WilkinsonEyre File Note

Date: 22 February 2024
 Project Name: Oxford North Plot B
 Job No/File Ref: Section 73 Drawing Submission Amendments

Section 73 Drawing Submission Amendments Schedule:

Drawing and CAD File Number  
01997 - WEA - XX - 00 - DR - A - P1000

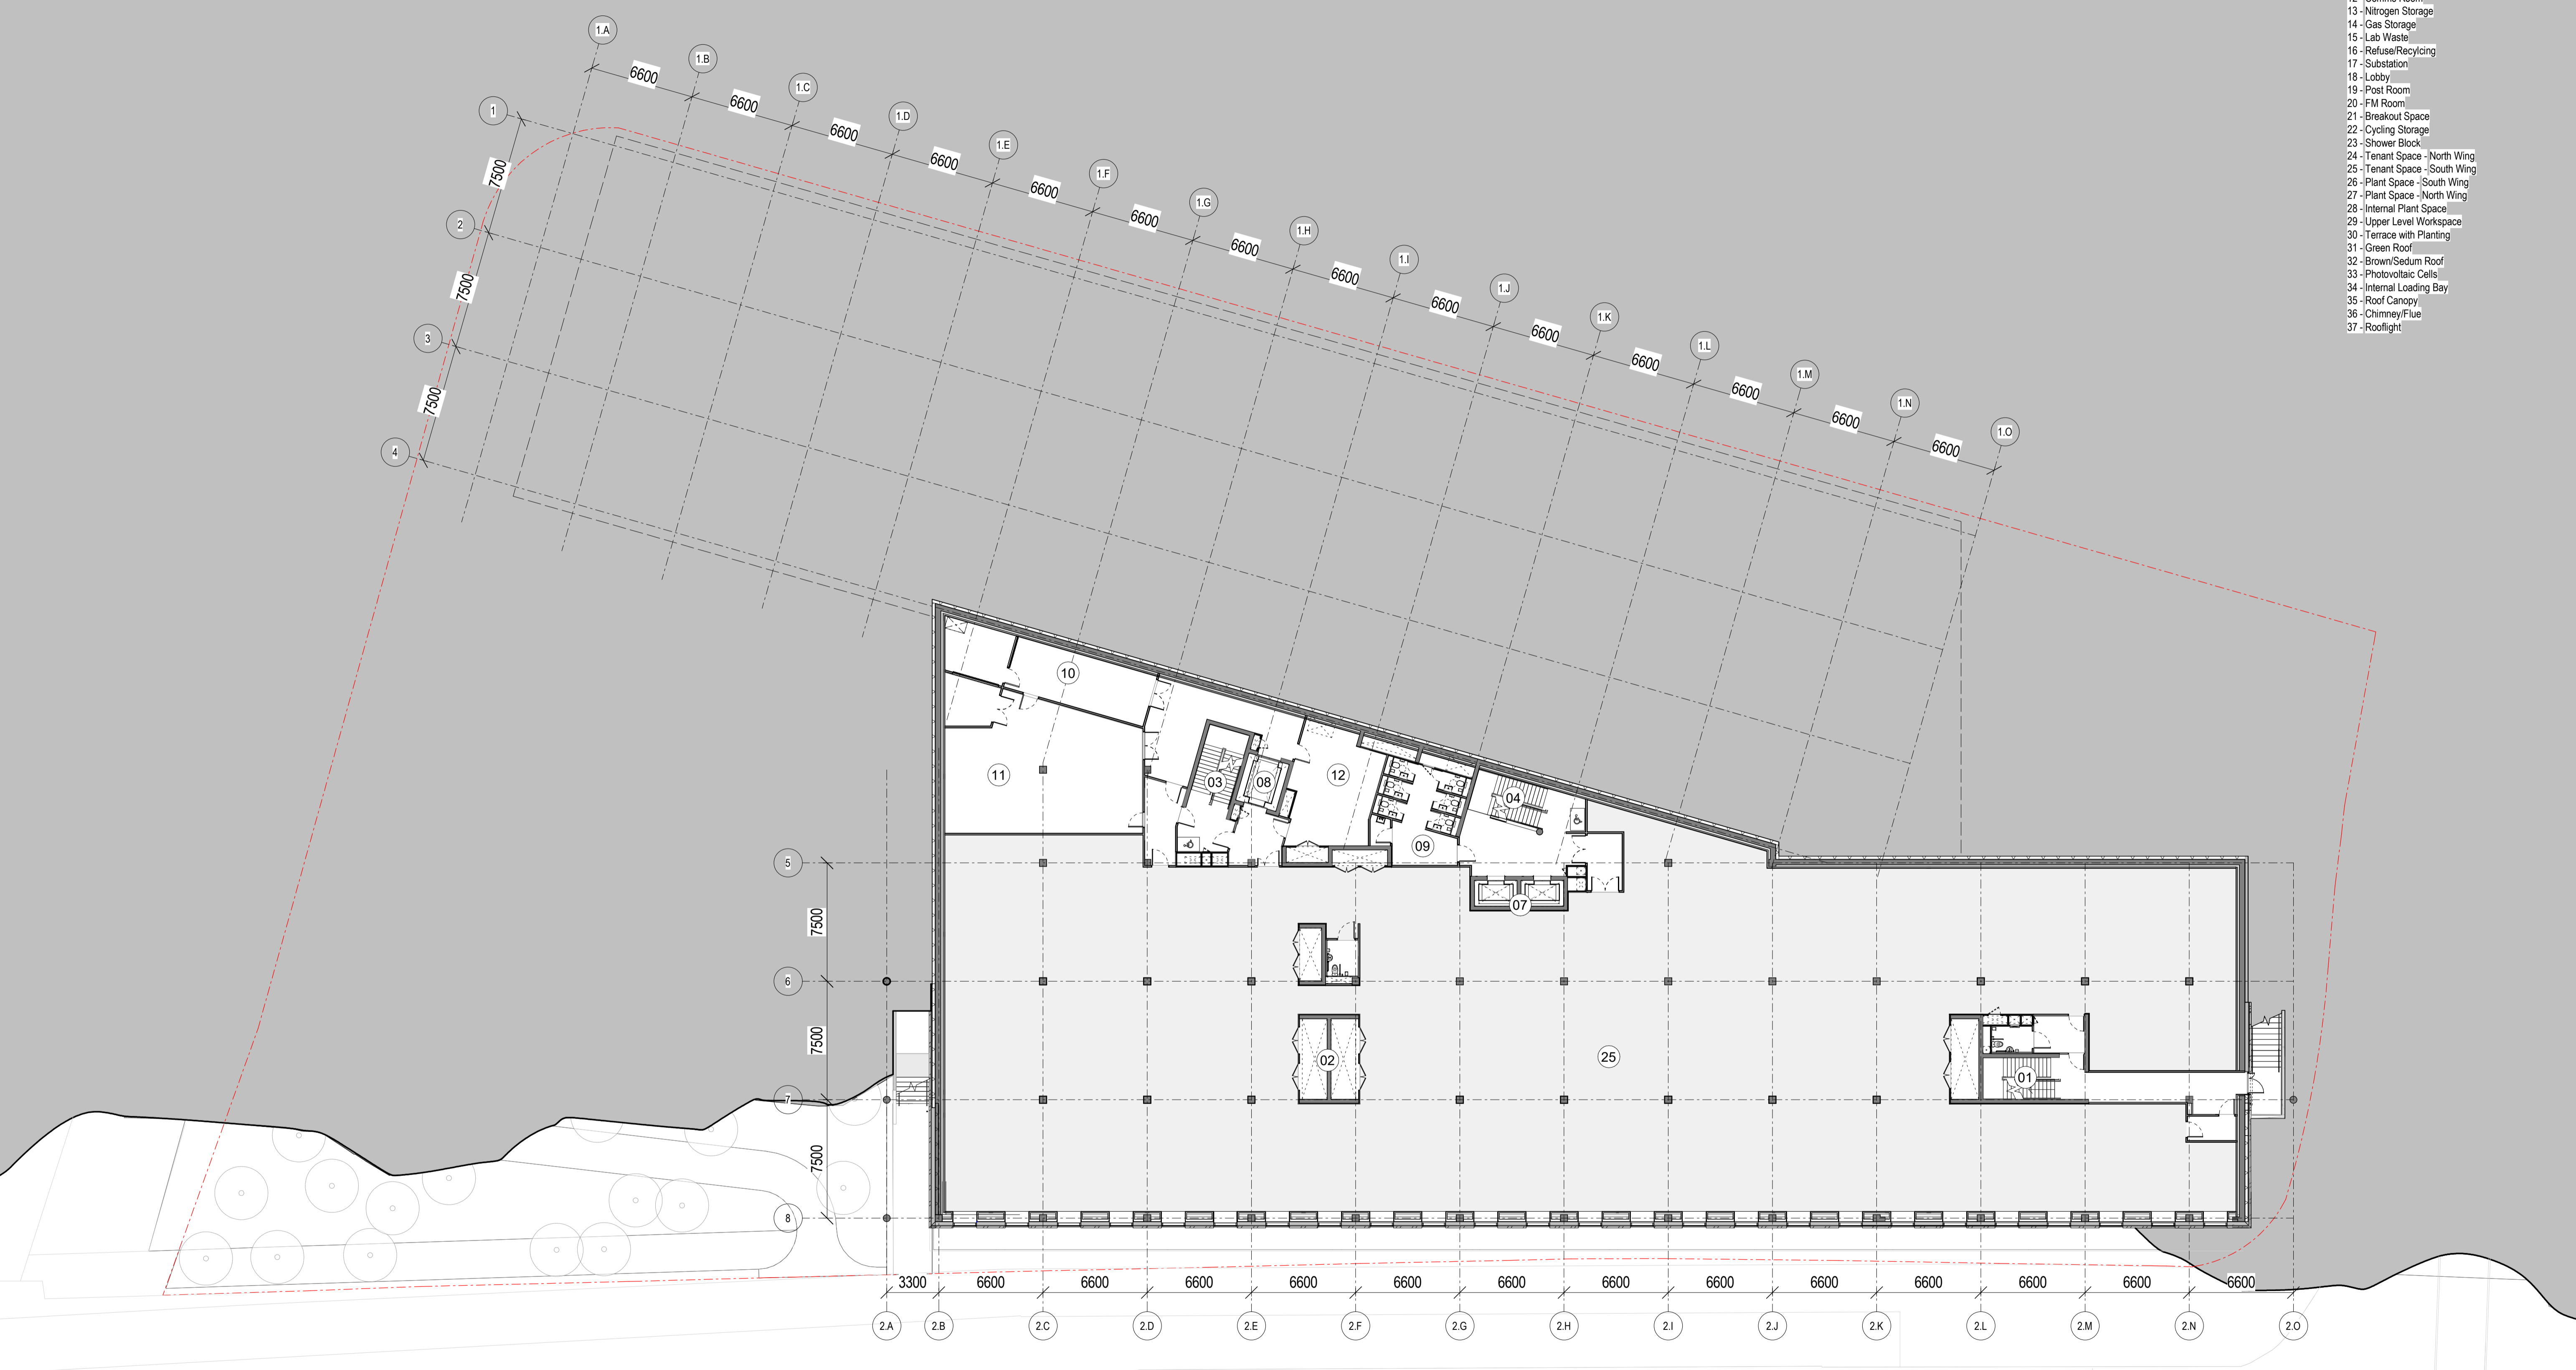
1000		PLANS	AMENDMENTS
1997-WEA-XX-XX-DR-A-P1000	1:200	Level 00 – Plan	Internal Central Core layout amended. Internal Satellite Core layout amended. Internal Riser layouts amended. Intake Plant Room layout amendments.
1997-WEA-XX-XX-DR-A-P1001	1:200	Level 01 - Plan	Internal Central Core layout amended. Internal Satellite Core layouts amended. Internal Riser layouts amended. Eastern entrance façade angle amended. Reception layout amended. FM and Post Room relocated to western side with loading bay reduced. Service Pavilion amended with standard substation units incorporated to west side. Eastern forecourt layout amended. Western landscape path radius amended.
1997-WEA-XX-XX-DR-A-P1002	1:200	Level 02 - Plan	Internal Central Core layout amended. Internal Satellite Core layouts amended. Internal Riser layouts amended. Eastern entrance façade angle amended. Void above reception area removed.
1997-WEA-XX-XX-DR-A-P1003	1:200	Level 03 - Plan	Internal Central Core layout amended. Internal Satellite Core layouts amended. Internal Riser layouts amended. Eastern entrance façade angle amended.

Scale at A1
As indicated
Drawing and CAD File Number
01997 - WEA - XX - XX - DR - A - P4002
Rev
P02

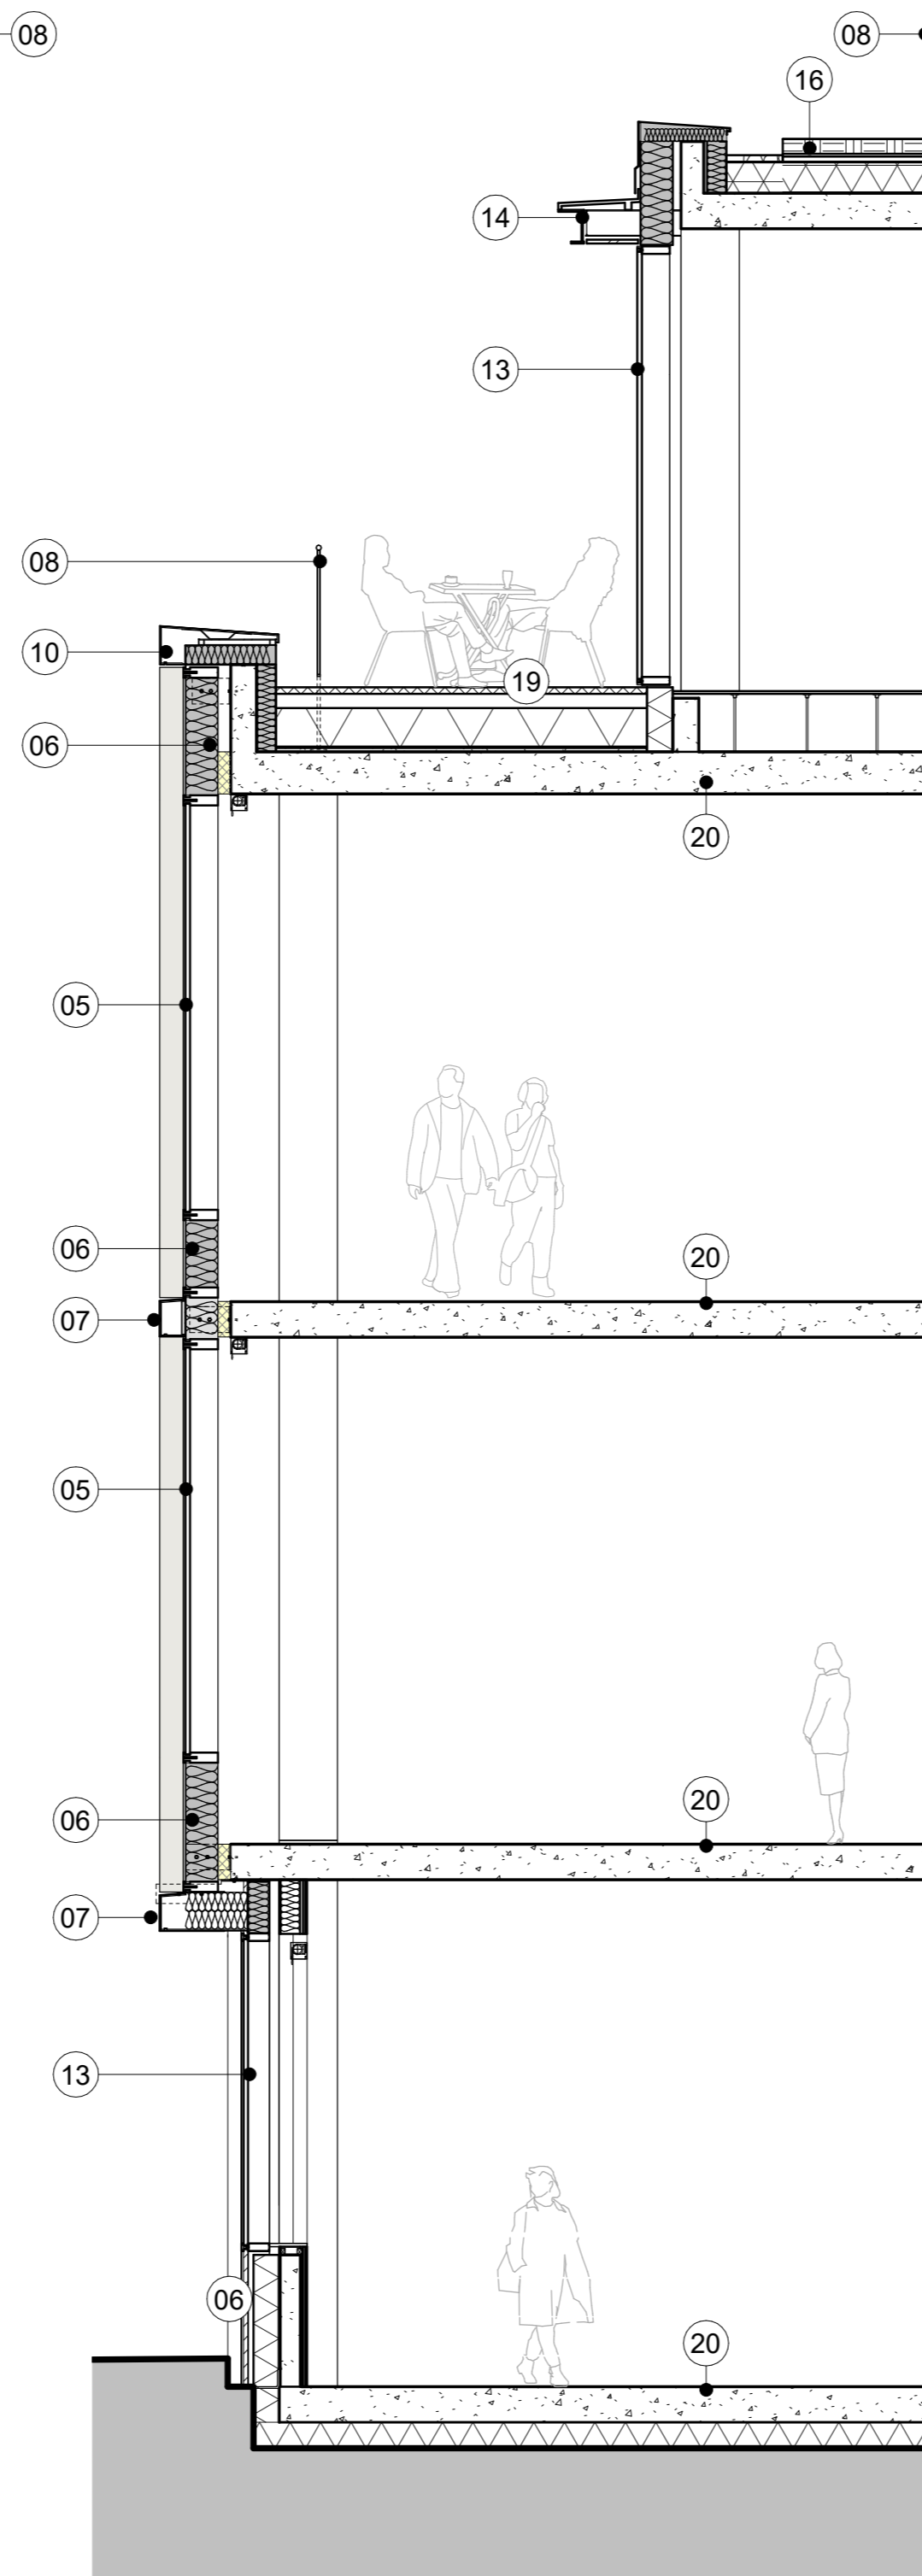
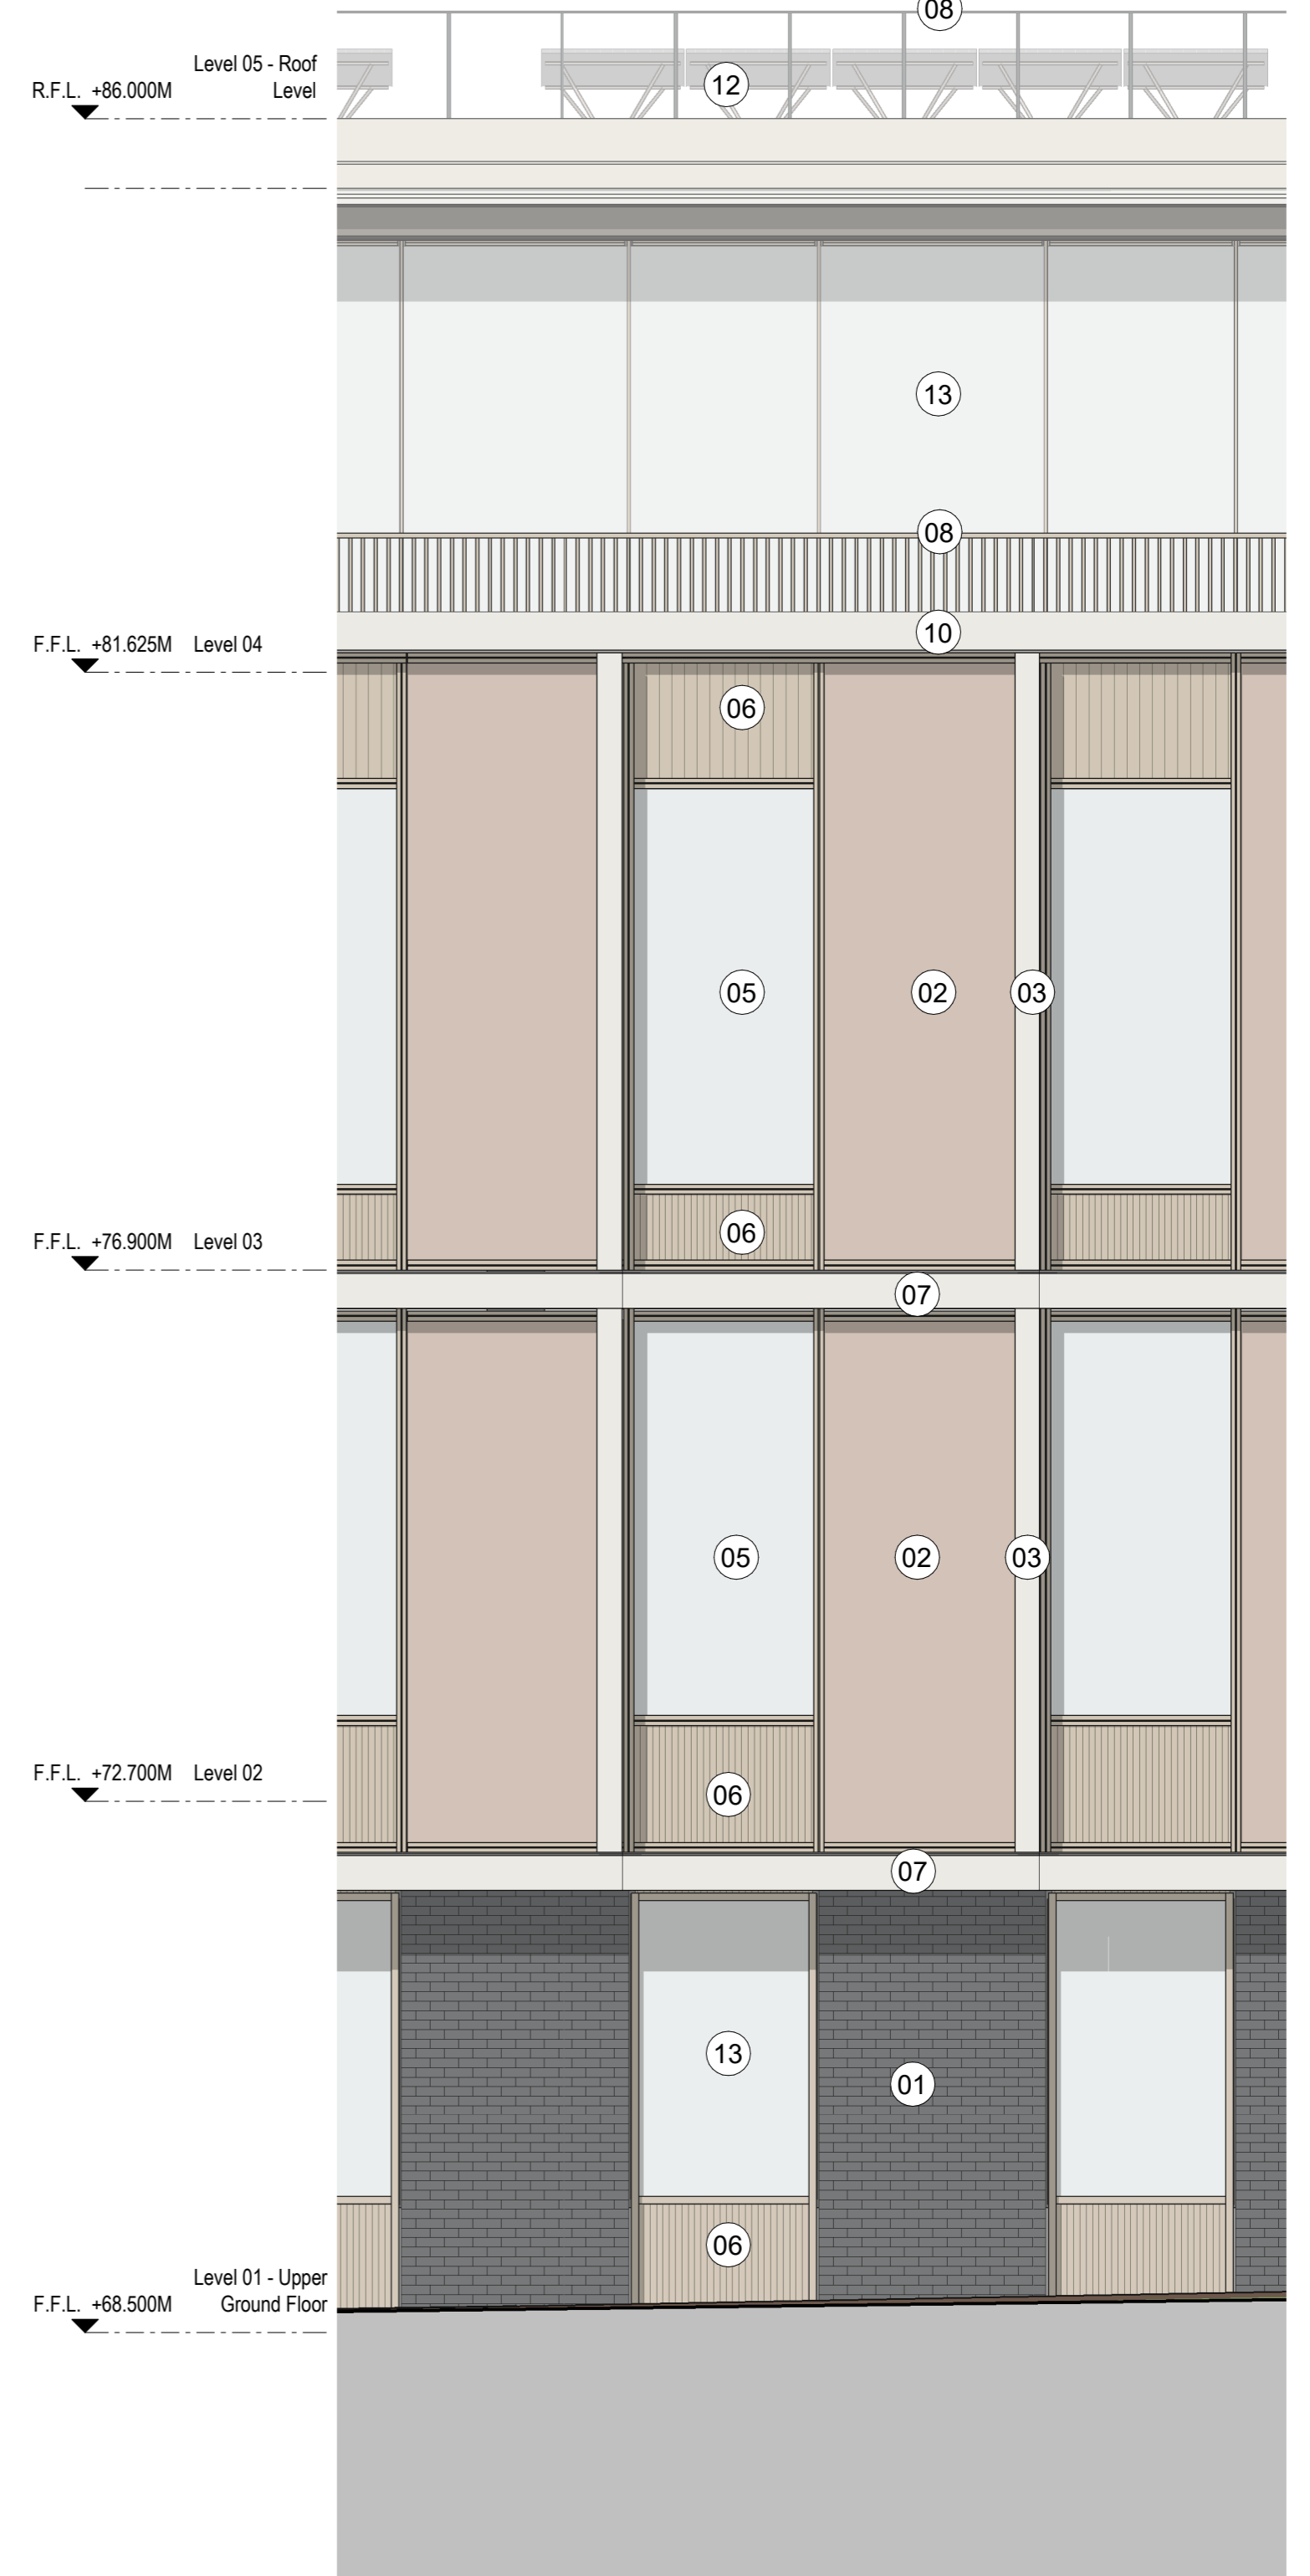
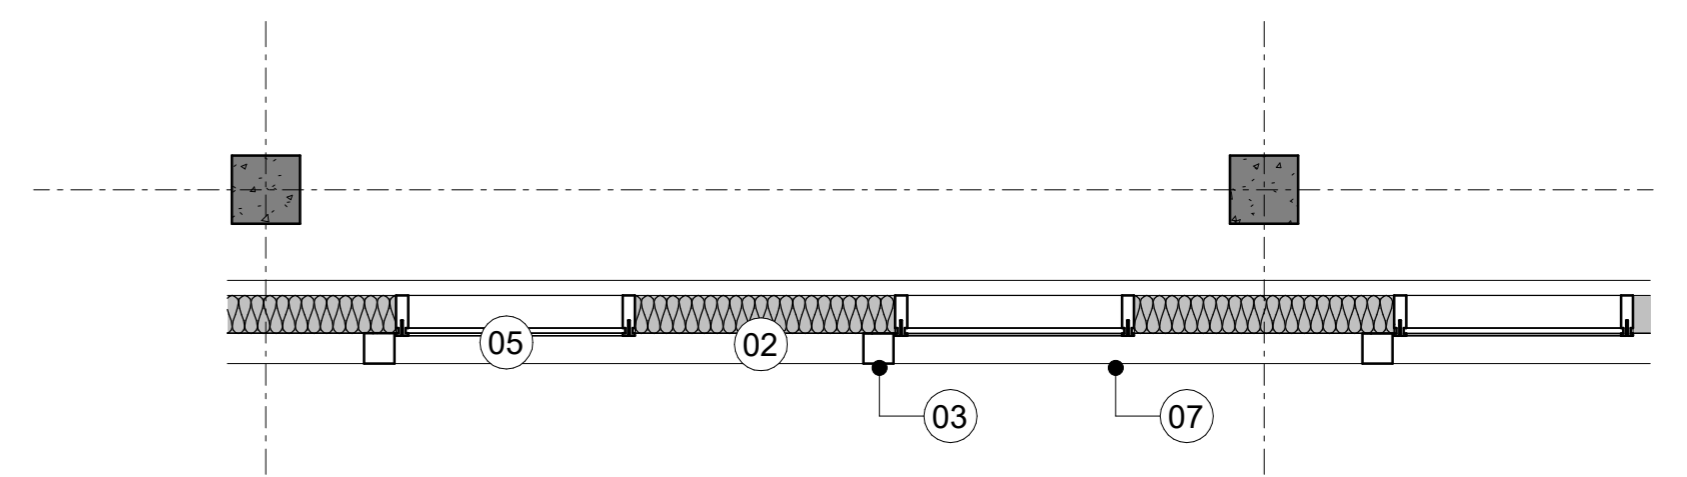
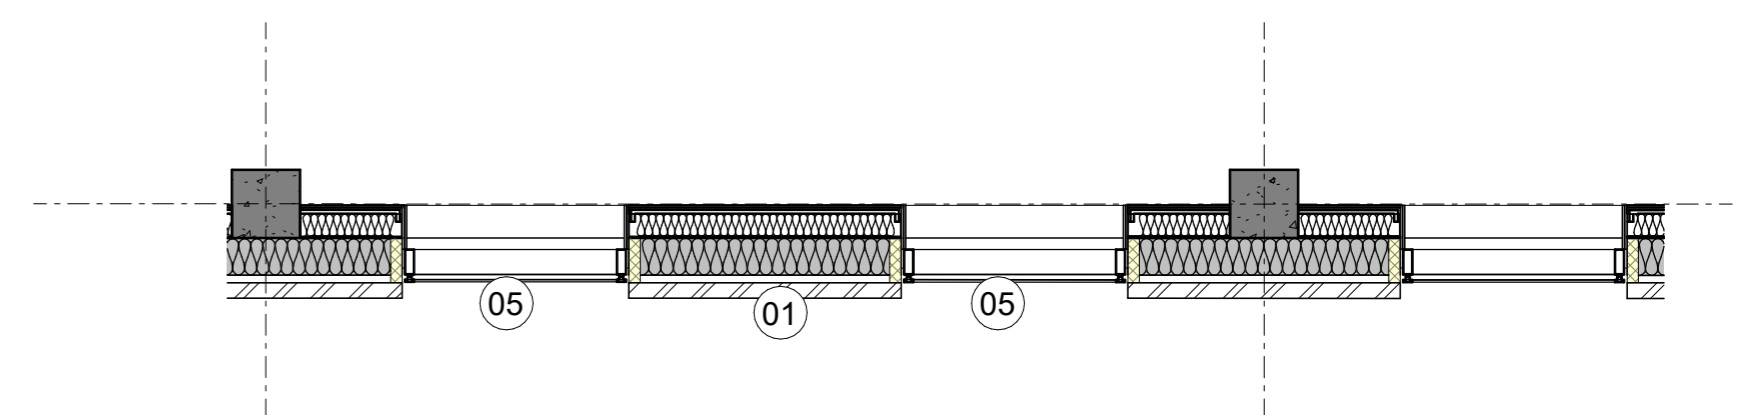
1997-WEA-XX-XX-DR-A-P4002	1:50	Northern Wing Typical Bay Study	Projecting cladding profiles reduced in 100mm in depth. Projecting vertical cladding profiles reduced 100mm in width.
1997-WEA-XX-XX-DR-A-P4003	1:50	Northern Wing Entrance Facade Study	Eastern entrance façade angle amended. Eastern façade entrance canopy removed. Glazing screen to elevation not recessed and widened with horizontal projection introduced. Flat cladding to gable end facades amended to projecting fins. Void above reception area removed. Soffit areas amended to metal.
1997-WEA-XX-XX-DR-A-P4004	1:50	Southern Wing Gable End Bay Study	Glazing setting out to gable end façade amended with horizontal projection introduced. Flat cladding to gable end facades amended to projecting fins. Level 01 window moved along elevation to avoid overlap with escape stair. Soffit areas amended to metal.
